Application: SSI 7485

I write regarding the proposed modification to M4-M5 Link, Mod 2 The Crescent overpass and changes to pedestrian infrastructure in North Annandale, Rozelle and Rozelle Bay Foreshore area.

Figure 4-2 Pedestrian and cyclist bridge infrastructure options

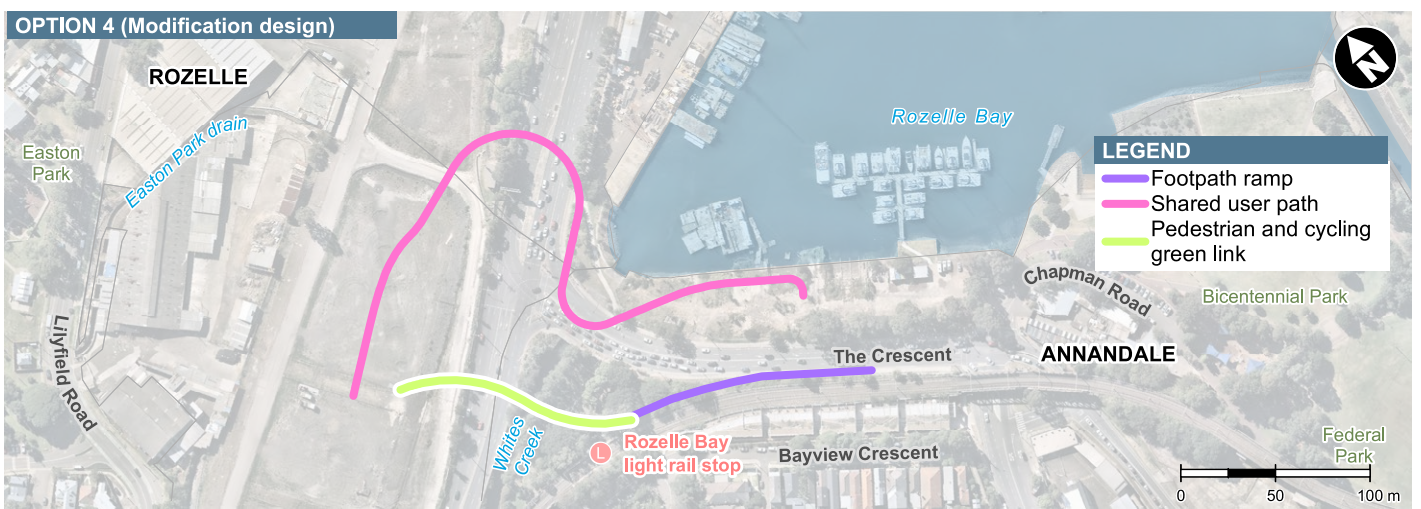
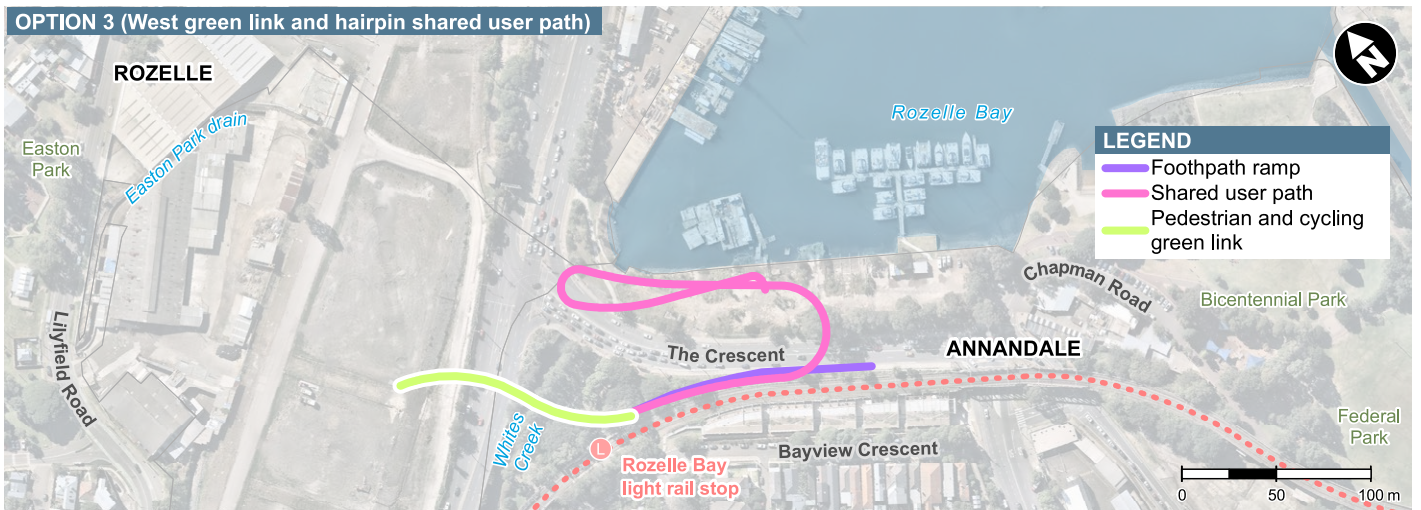
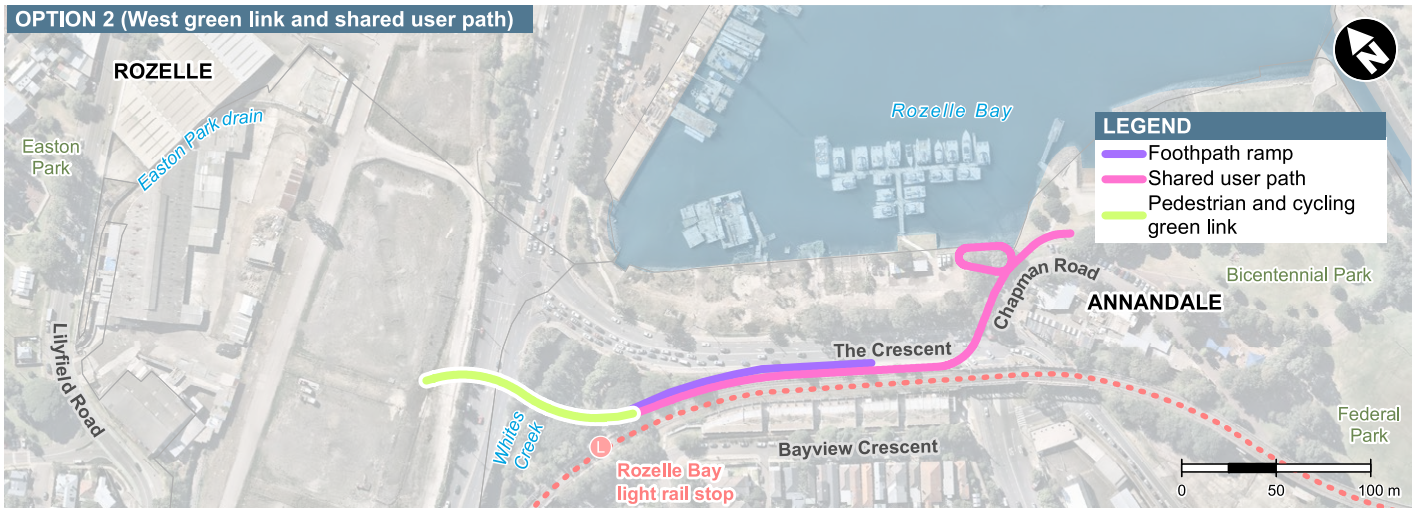
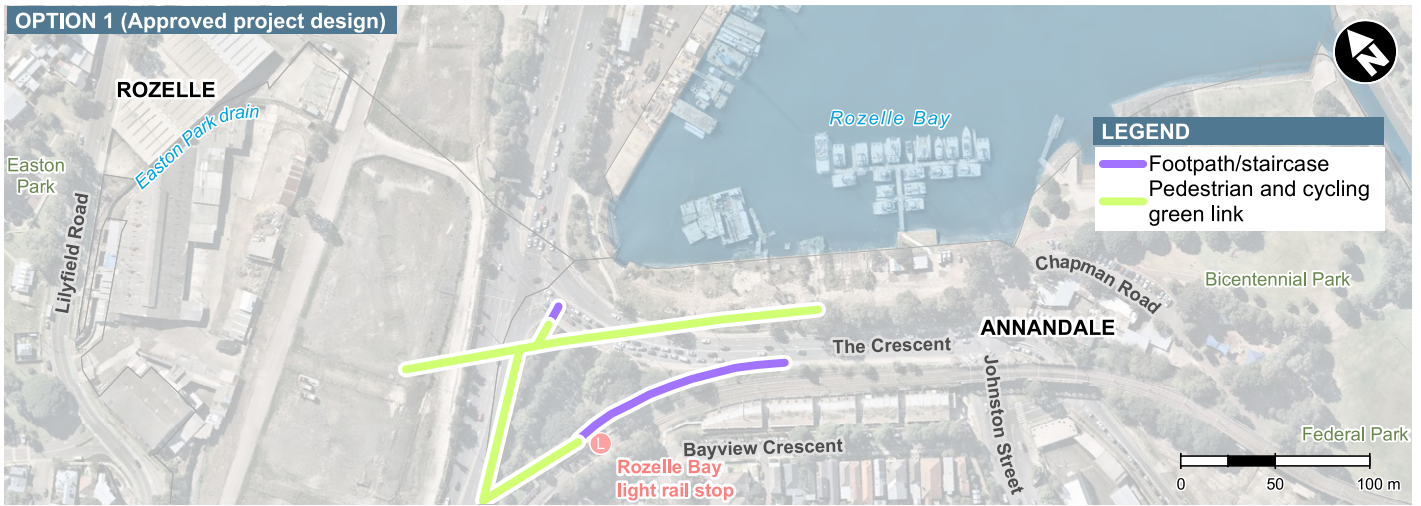
I request RMS work with the community to explore alternate design options to the proposed new car overpass design and the changed pedestrian and cyclist links. I am seeking the reinstatement of the safe, direct access from the approved EIS GreenLink to create a continuous green open space connection from the Rozelle Rail yards and Annandale to the foreshore. The GreenLink was more than just a walk way - it put people central to the design, maximising safety, and providing much needed accessible open space for the community now and into the future Bays Precinct design.

- Removal of direct active links to the foreshore, cutting the community off from the area and the proposed revitalisation of the entire Bays Precinct, including linking the Light Rail and Bus stops to a Ferry wharf and Metro station.

- Reinstatement of the GreenLink connecting communities and green open space from Rozelle to Bicentennial Park
- Relocate and design pedestrian and cyclist connections that are continuous, safe and direct.
- Design the modification infrastructure and active links in response to the character of the suburbs, the location of the foreshore and its potential future development.
- Provide pedestrian and cyclist paths that maximise people safety and do not force them onto busier streets, unsafe concrete plazas and caged walkways.
- Prevent this redevelopment from eroding the local villages and keep pedestrians safe by limiting the traffic pushed into small suburban roads.
- Integrate active and direct connections to all active transport – including the future Metro West and Foreshore Ferry Wharf

Figure 4-4 Elevation: Indicative view of The Crescent overpass

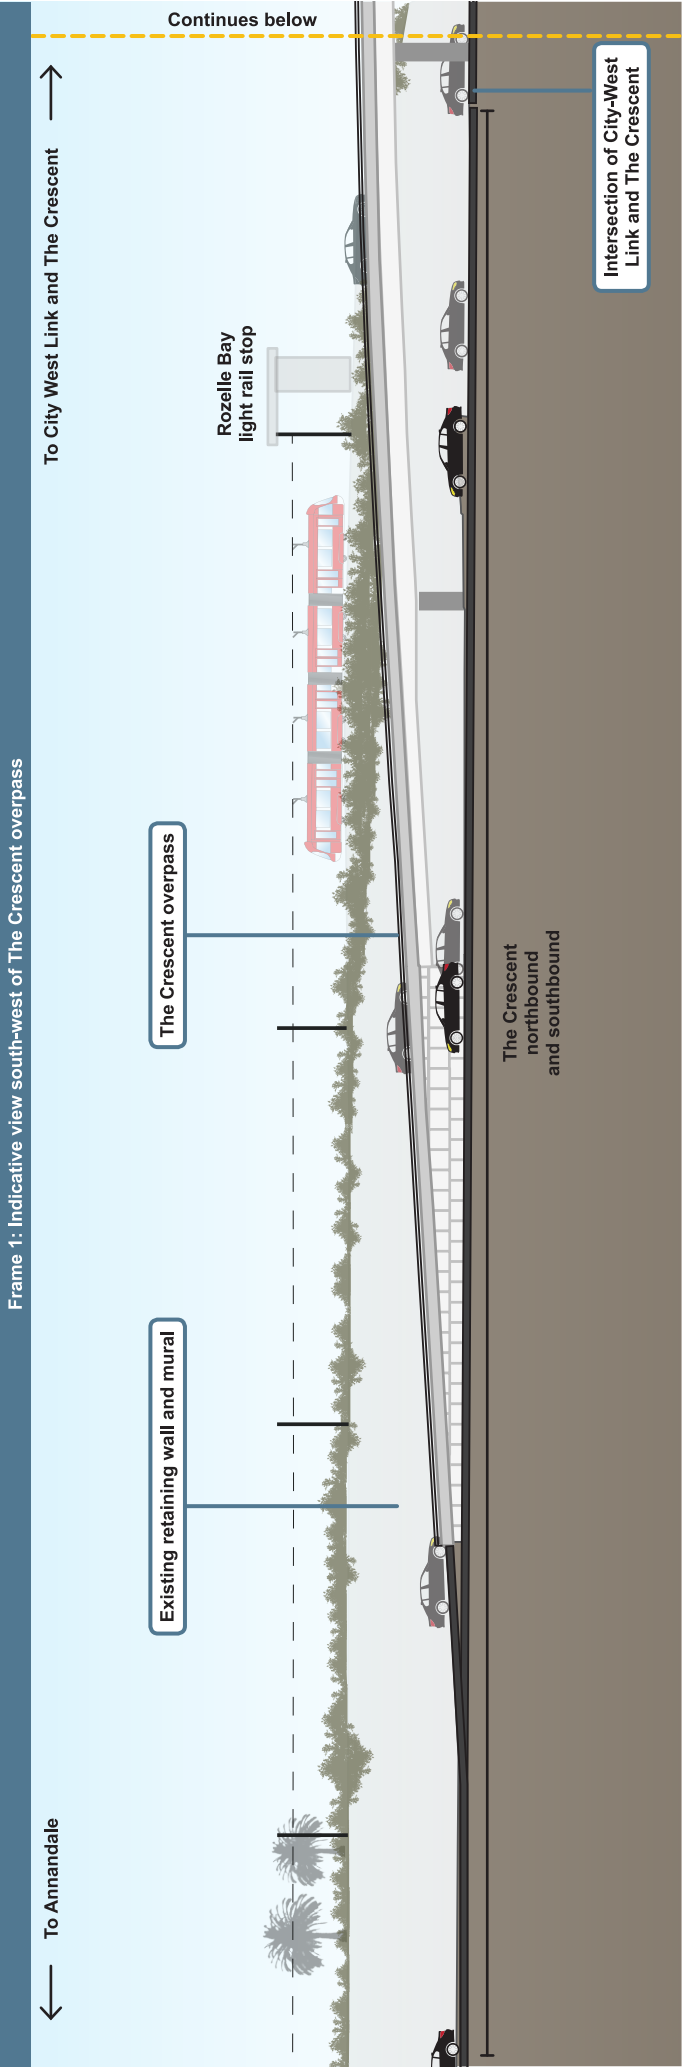
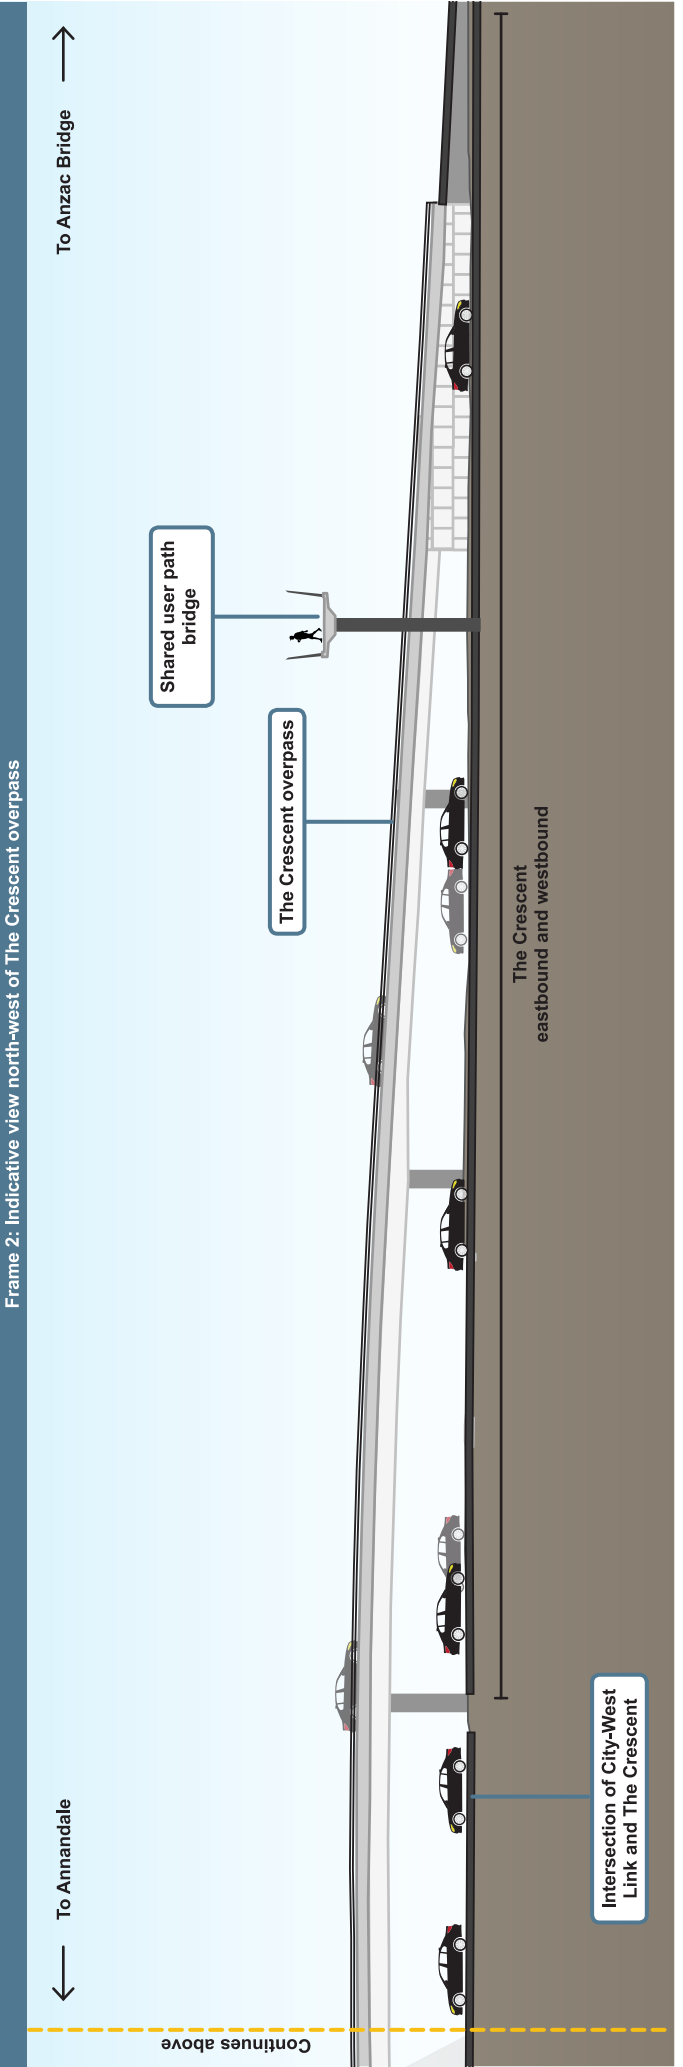
- The prioritisation of an environmentally-damaging and profit-focused toll road over the community
- The significantly reduced safety and increased risk for pedestrians and cyclists with removed access over The Crescent to Bicentennial Park and the increased traffic along Johnson Street.

- Being required to cross five sets of pedestrian lights at The Crescent to reach the foreshore from Annandale or from Rozelle Bay light rail stop, decreasing utilisation of public transport and likely resulting in jaywalking due to frustration

Annandale village is designed around local traffic, however this project pushes more and more vehicles onto these local roads, endangering children and other pedestrians. This affects local businesses, as they are inaccessible with through traffic blocking access. The pedestrian crossings in this area are frequently ignored by frustrated motorists, and the 4 lane modification to the Crescent will only increase this issue.
